CITY OF ALBUQUERQUE

RE: **Beehive Homes** – SW Corner Four Hills Road and Wenonah NE **L23/E022**
Four Hills Village Shopping Center, Tract 1-B2 **PE Stamp: 10/15/13**
Erosion & Sediment Control Plan for Building Permit – Phase 1

Based upon the information provided in your submittal received 10/18/2013, the above referenced plan is cannot be approved as the **Erosion and Sediment Control Plan for Phase 1 improvements on this site.**

ENGINEER'S SEAL	BEEHIVE HOMES	DRAWN BY WCUJ
DAVID SOULE NEW MEXICO REGISTERED PROFESSIONAL ENGINEER 14522	GRADING AND DRAINAGE PLAN	DATE 10-02-13
	Rio Grande Engineering 1606 CENTRAL AVENUE SUITE 201 ALBUQUERQUE, NM 87106 (505) 872-0999	21227-AYOUT-7-13-12
		SHEET # 1
		JOB # 21227

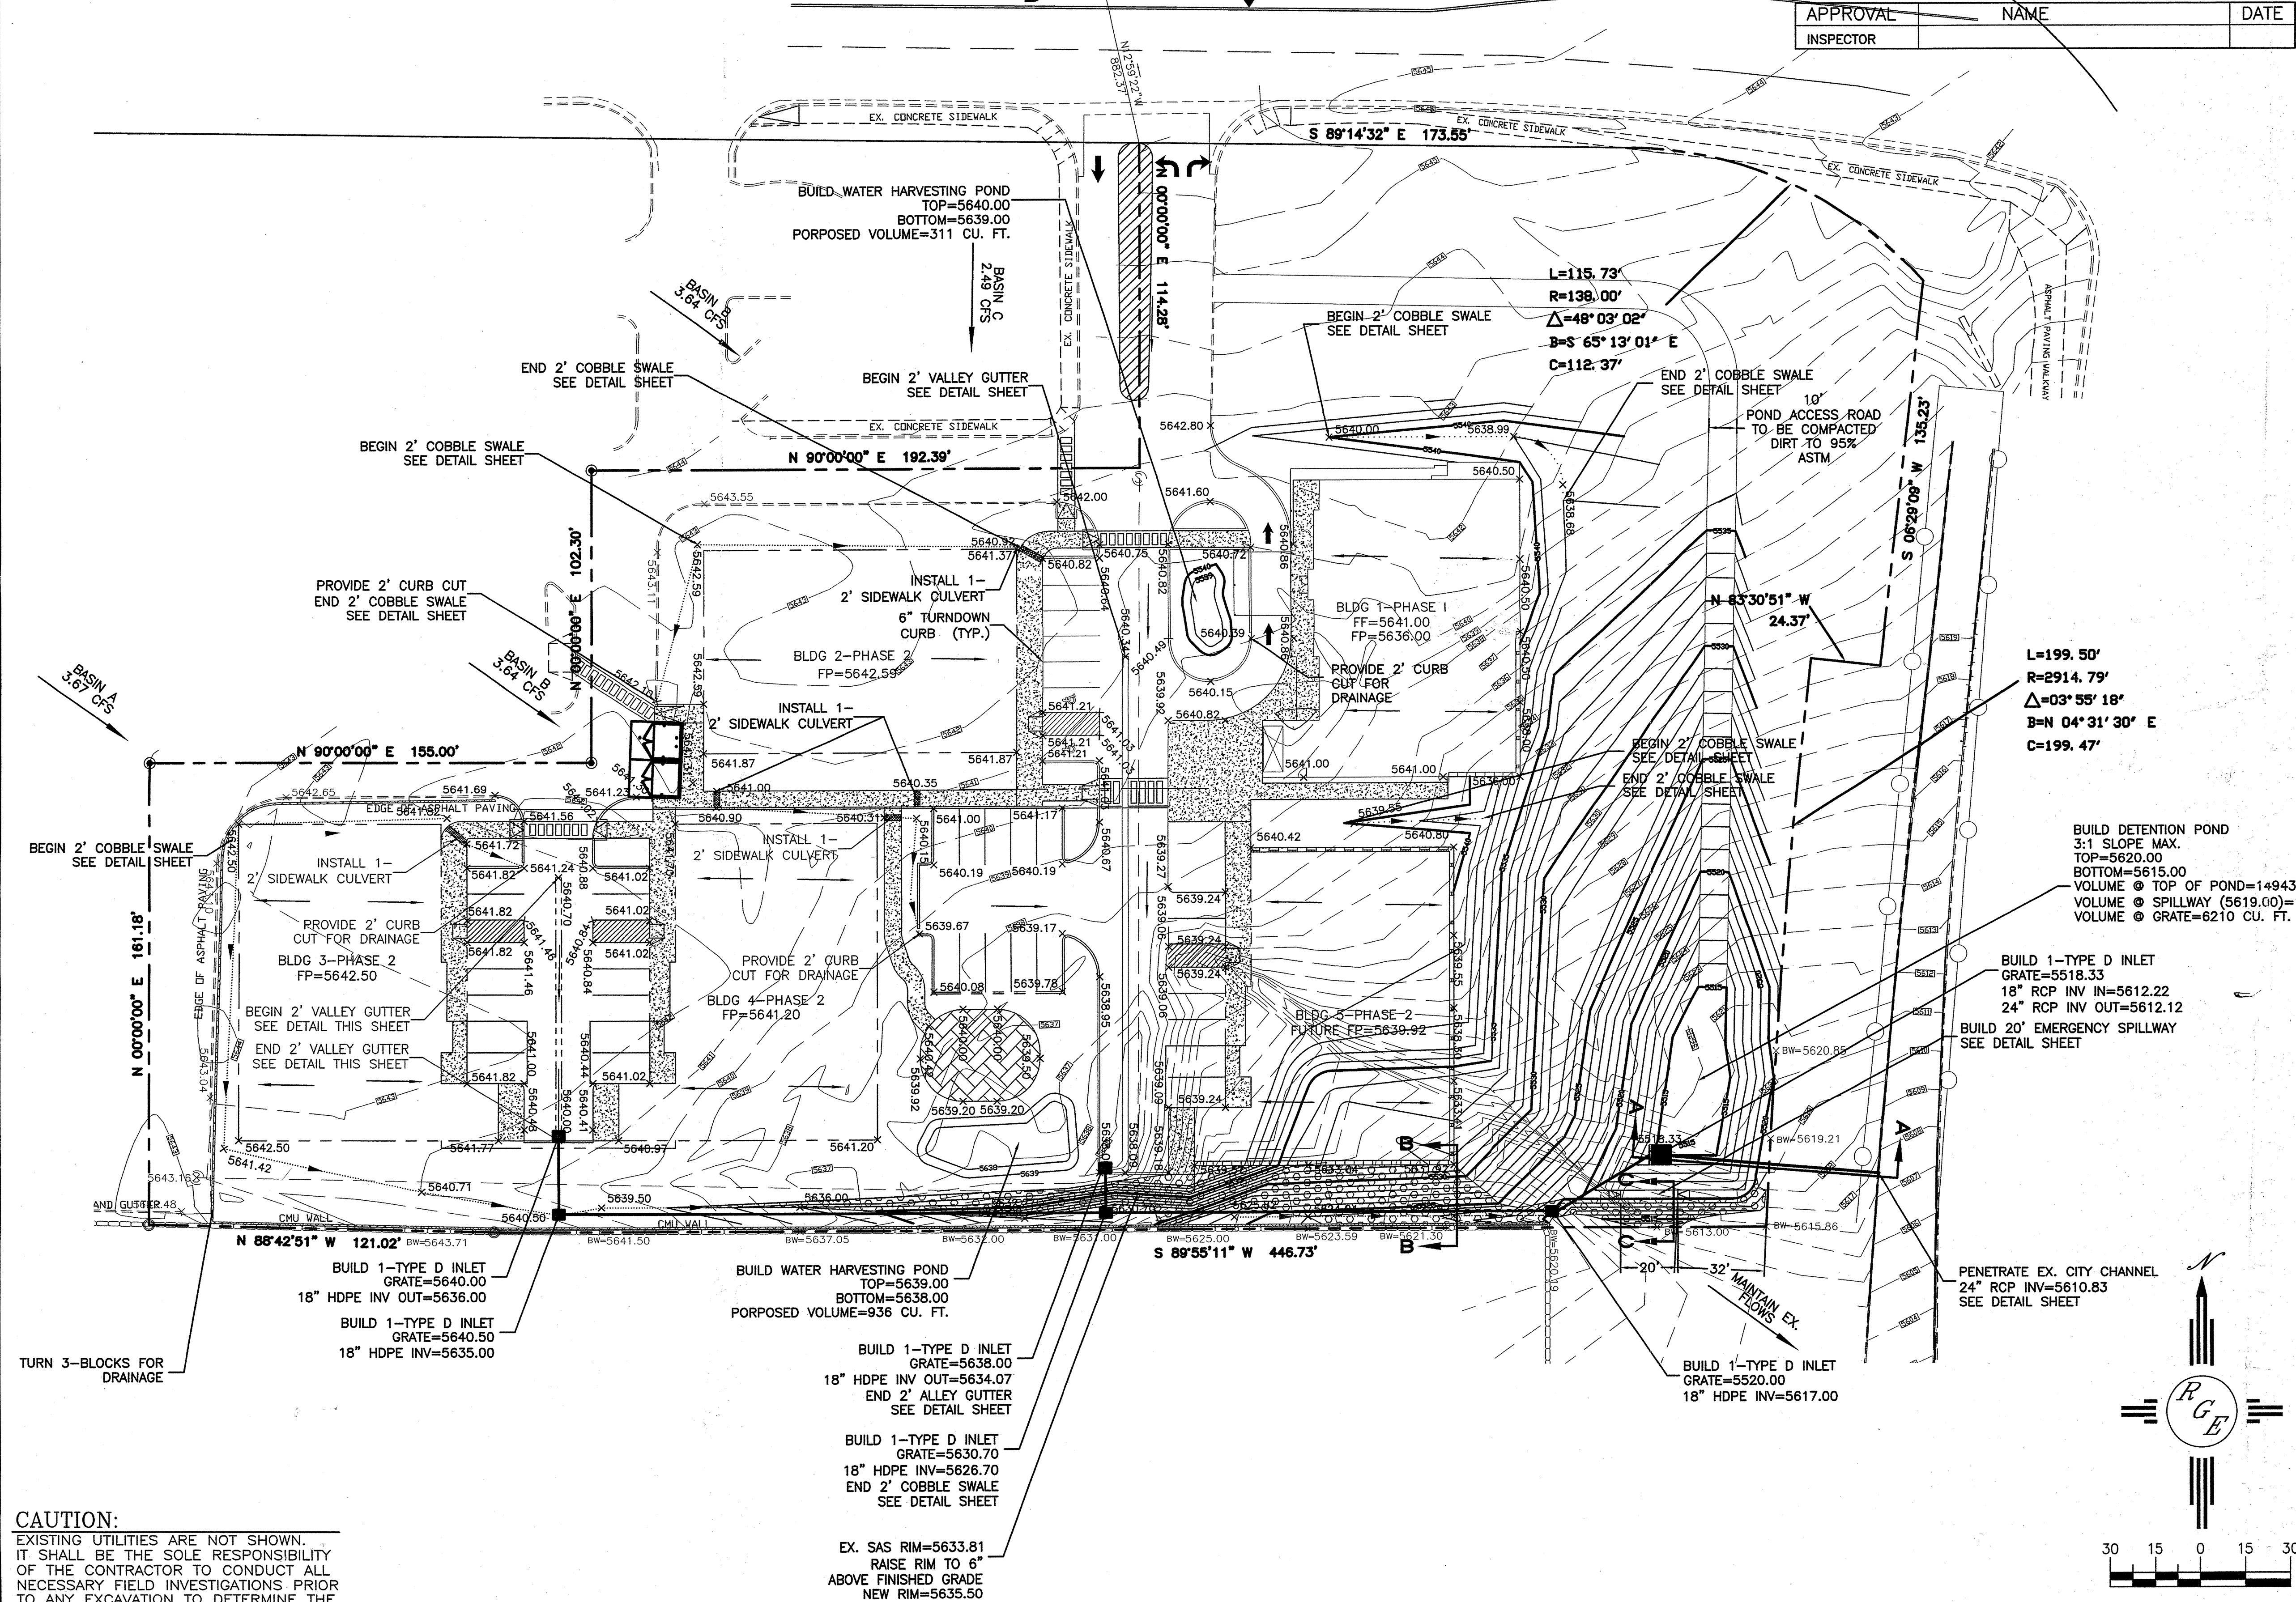
1. Construction of the Phase 1 Building and improvements needs to include adequate, drainage improvements to support the post-construction runoff. The northern and southern boundaries exclude areas that will be affected by this phase.

- a. If the intent is to grade the entire site and construct all G&D improvements, then expand the ESC Plan to cover the entire site.
 - b. If the intent is to only grade a portion of the site for each phase, then it may be easiest to amend the G&D Plan to reflect the “Phased” G&D improvements, and include any necessary “Interim BPM’s” to protect the disturbed areas and the constructed, permanent improvements.

2. Phased construction must provide adequate, permanent or interim protection at points where flows enter and leave the site. As a minimum, Phase 1 needs to include construction of the permanent drainage outfall for the site.

3. This plan shows a Block Wall (BW) and sidewalk along the south edge of Phase 2, Building 4, which is inconsistent with the approved G&D. For clarity, it would be better to develop your ESC Plan on a G&D base plan.
